Design Note

Project Begbroke Innovation District
Subject Buro Happold's Response to LLFA Interim Consultation
Project no 0052188
Date 26 October 2023

Oxfordshire County Council (OCC) has provided an interim response to consultation for the Begbroke Innovation District planning application (Ref: 23/02098/OUT). This has included detailed comments made by the Lead Local Flood Authority (LLFA) dated 29/8/23. The note provides a response to the comments made by the LLFA, which are shown in red text.

Figure 5—3 Overall Site drainage catchments

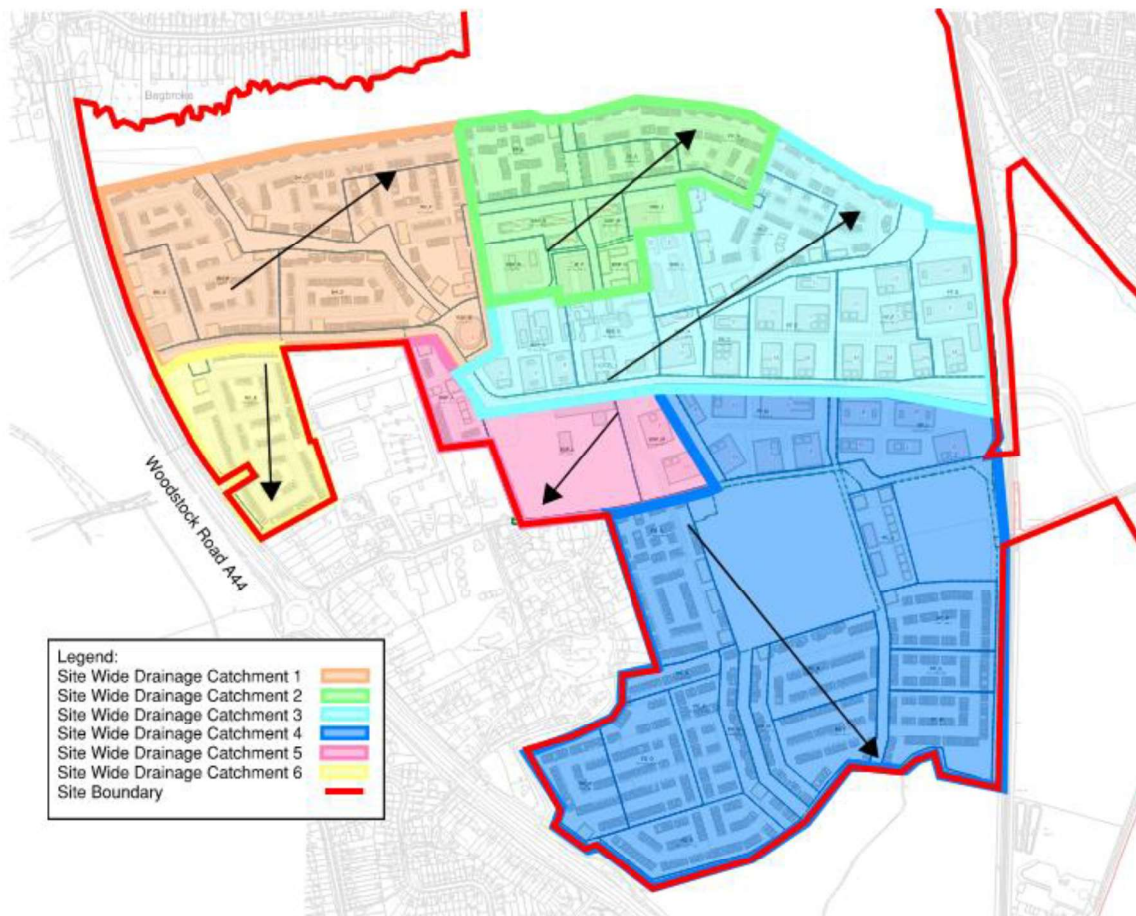
LLFA Comment 1: Table 2-5 refers to existing catchments and their proposed outfalls, it's unclear where these catchments are as they are not shown on plan. Provide surface water catchment plan stating the catchments and the locations of the outfalls and discharge rates.

LLFA Comment 7: Surface water catchment plan to be provided, showing the extent of the impermeable areas, and stating the area after allowing for 10% urban creep.

Buro Happold (BH) assumes this is an erroneous reference to Table 5-2 (there is no Table 2-5). Table 1 below (Table 5-2 in ODS) provides the existing greenfield run-off rates for multiple storm event scenarios as well as the QBAR rate. These are for the proposed site drainage catchments shown in Figure 2-1.

The proposed strategy aims to respect the existing catchments and attenuate surface water close to its source before discharging into the ground and/or to the three local watercourses. The discharge locations, discharge rates and attenuation volumes will be confirmed during the later stages of design and planning. An indicative assessment has been provided in section 5.4 of the ODS.

The outline drainage strategy has been designed based on the illustrative masterplan. An allowance for impermeable areas has been detailed within section 5.4.3.2 Runoff Volume Assessment detailing the process undertaken, to reflect the site constraints, and permeability of the site to demonstrate that the outline strategy would be feasible. A detailed

drainage strategy will be provided with reserved matters applications and will include the extent of impermeable areas, including an allowance for 10% urban creep.

Figure 5—4 Schematic Site Wide Drainage Layout

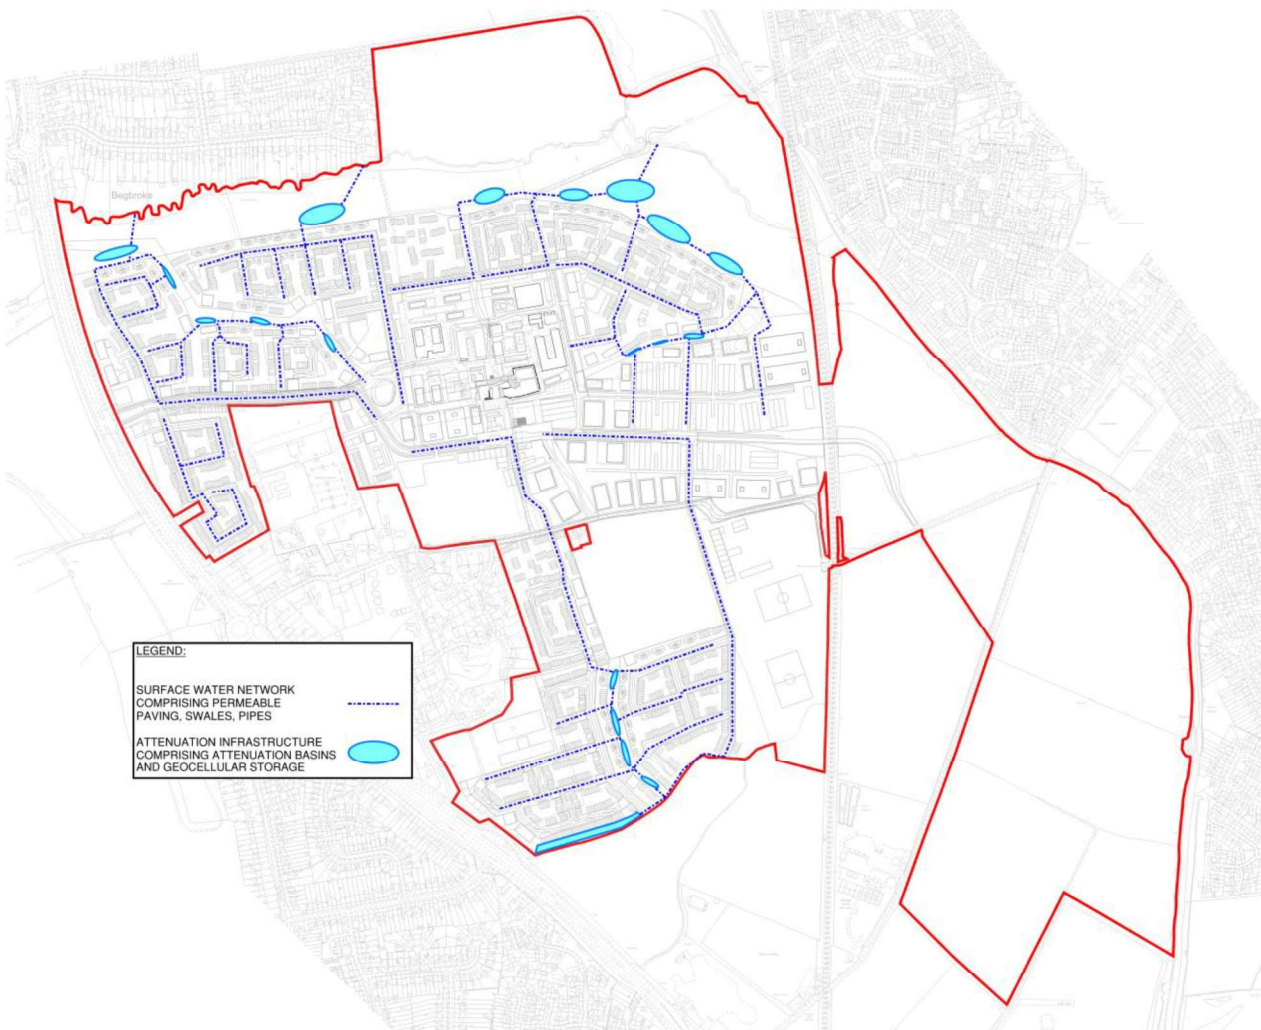
LLFA Comment 4: Provide agreed points of surface water discharge. Consent to be provided from the relevant party to make drainage connections and to confirm capacity of the existing outfalls, to ensure the proposed surface water loads does not increase flood risk to the neighbouring sites.

The proposed points of discharge are provided in Table 1 below (Table 5-2 in ODS). These are via infiltration and/ or watercourses. An illustrative site wide drainage layout is provided in Figure 5-4 of the ODS. The number and location of these points of discharge will be confirmed through later stages of design and planning as the masterplan is developed.

The proposed points of discharge are provided in Table 1 (Table 5-2 in ODS). These are via infiltration and/ or watercourses. The number and location of these points of discharge will be confirmed through later stages of design and planning as the masterplan is developed.

No connection to existing headwalls is proposed as part of the outline drainage strategy. Approval of any proposed outfall structures will be sought from the relevant consenting authority, acknowledging that the consenting process is separate to planning but will likely occur in parallel.
